RE: Planning application EP/55/12 – Land adjacent to 20 Eastern Close, East Preston

I wish to object to the application made to build a house on the land adjacent to 20 Eastern Close, East Preston. Our reasons are as follows:

PROPOSED DWELLING - ON LAND ADJACENT TO No. 20 EASTERN CLOSE

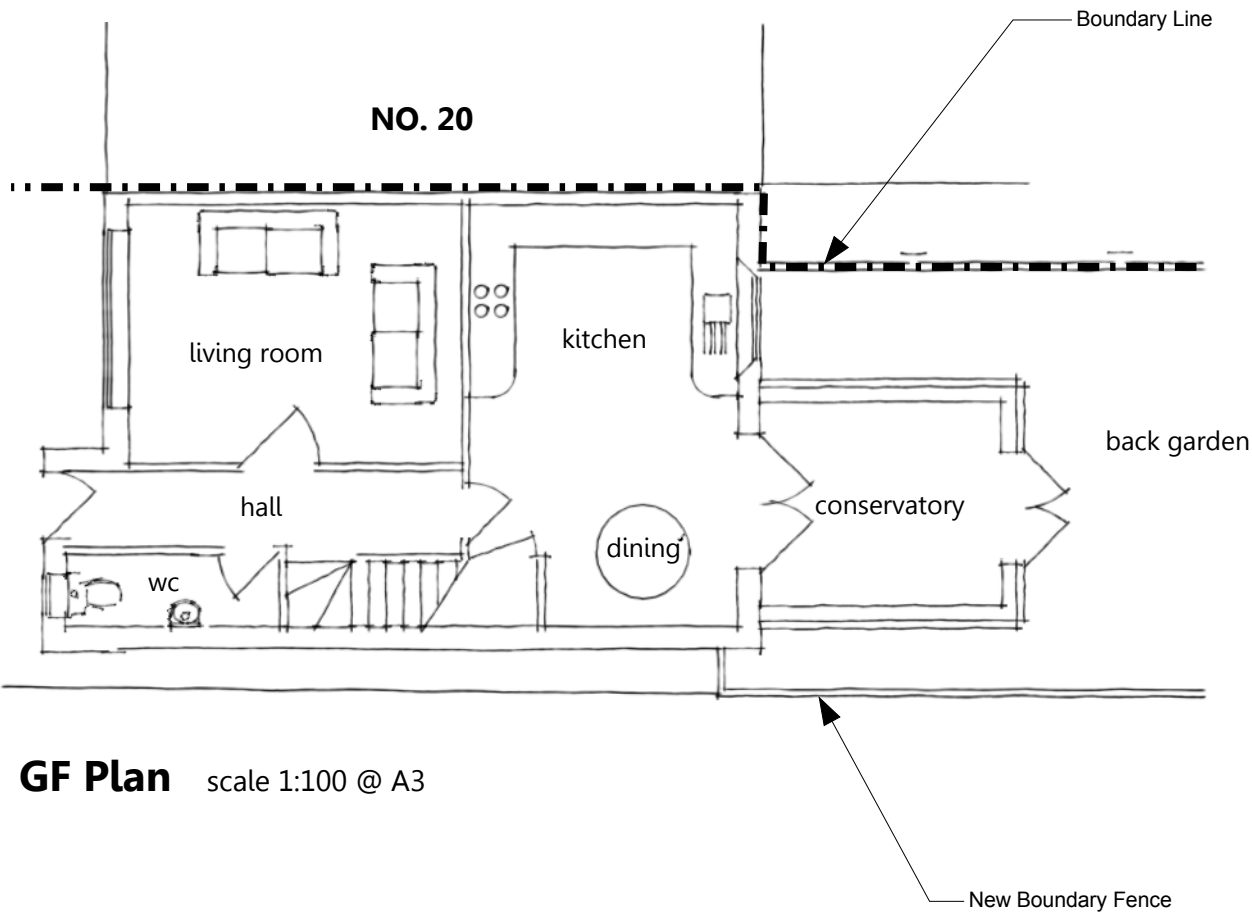
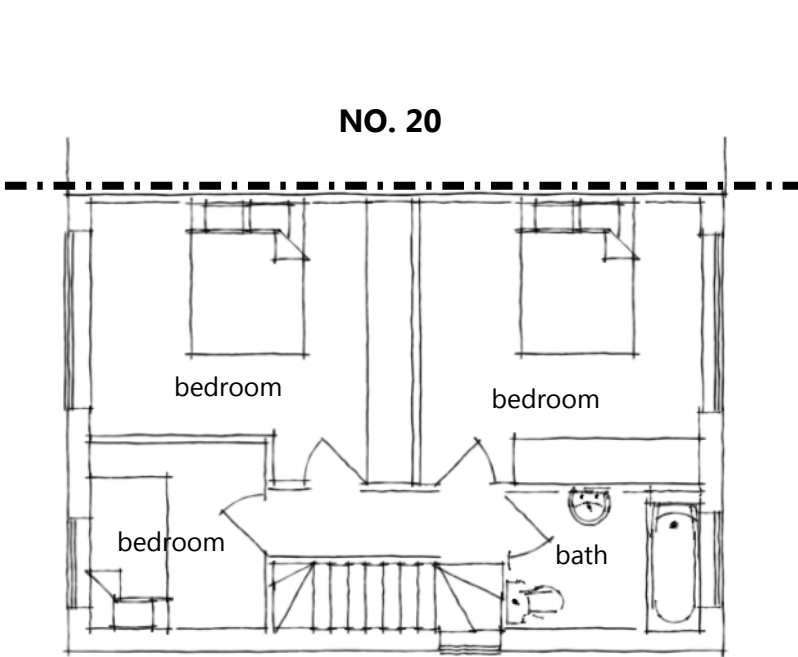
- Overlooking – The back bedroom window of the new house will enable a view point into our living room, and front bedrooms where our children sleep.
- Overlooking – Our front bedrooms would directly look into the garden of the new house.

South Elevation scale 1:100 @ A3

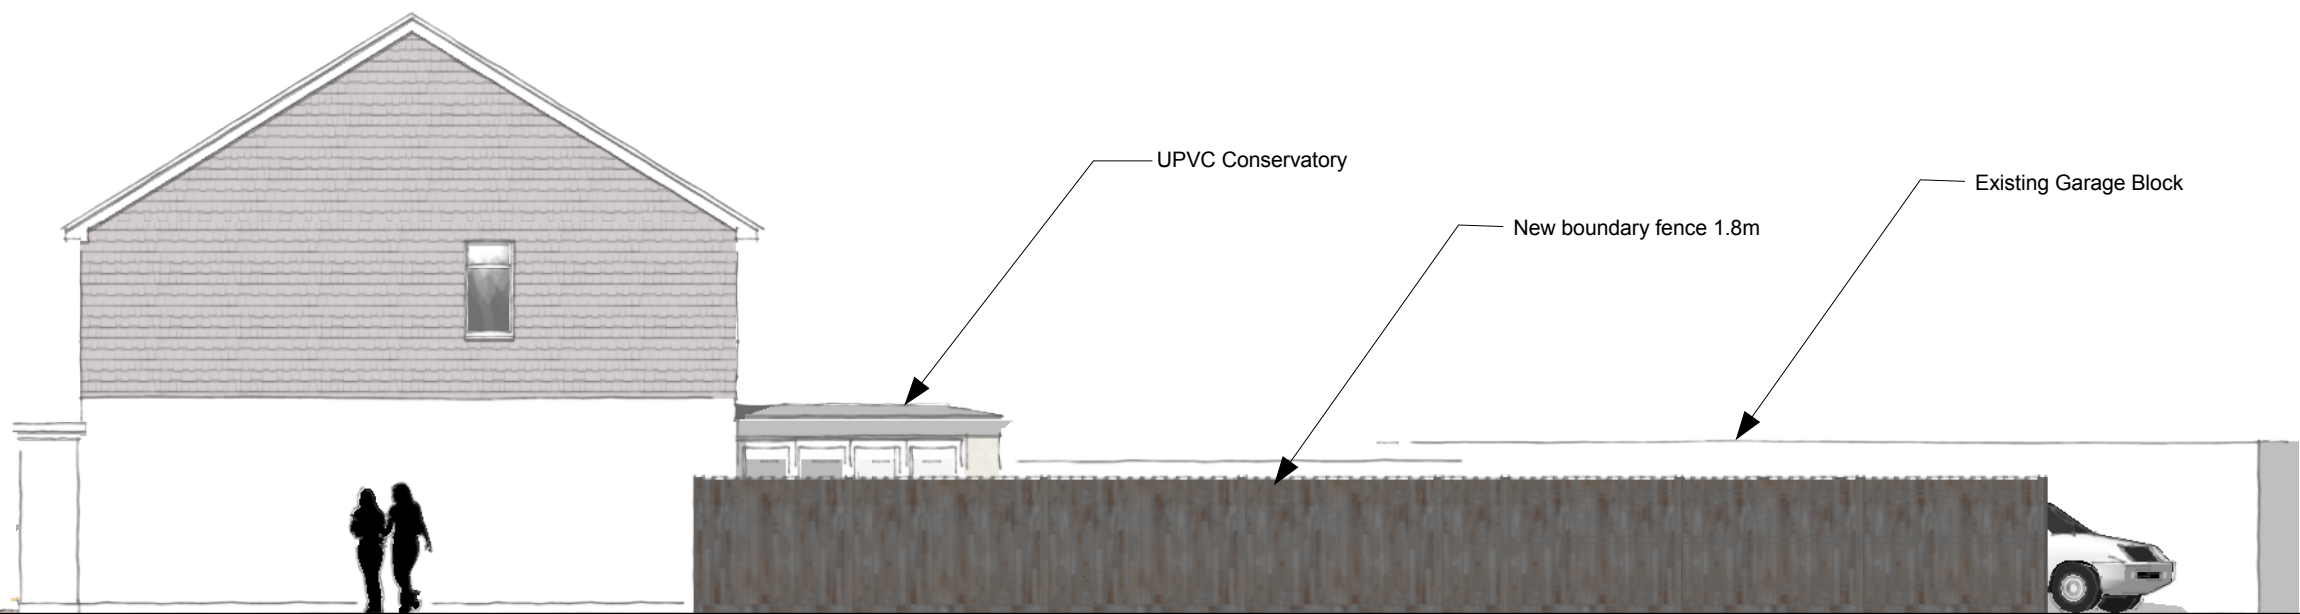
- Overlooking – the window on the plans on the south side wall would look directly into our living room and two front bedrooms.
- Parking – Parking is already an issue in the close with all car parking spaces being filled as well as cars parking on pavements. This occurs every day. Another house would potentially add 2 more cars to require parking here when this is already overcrowded.
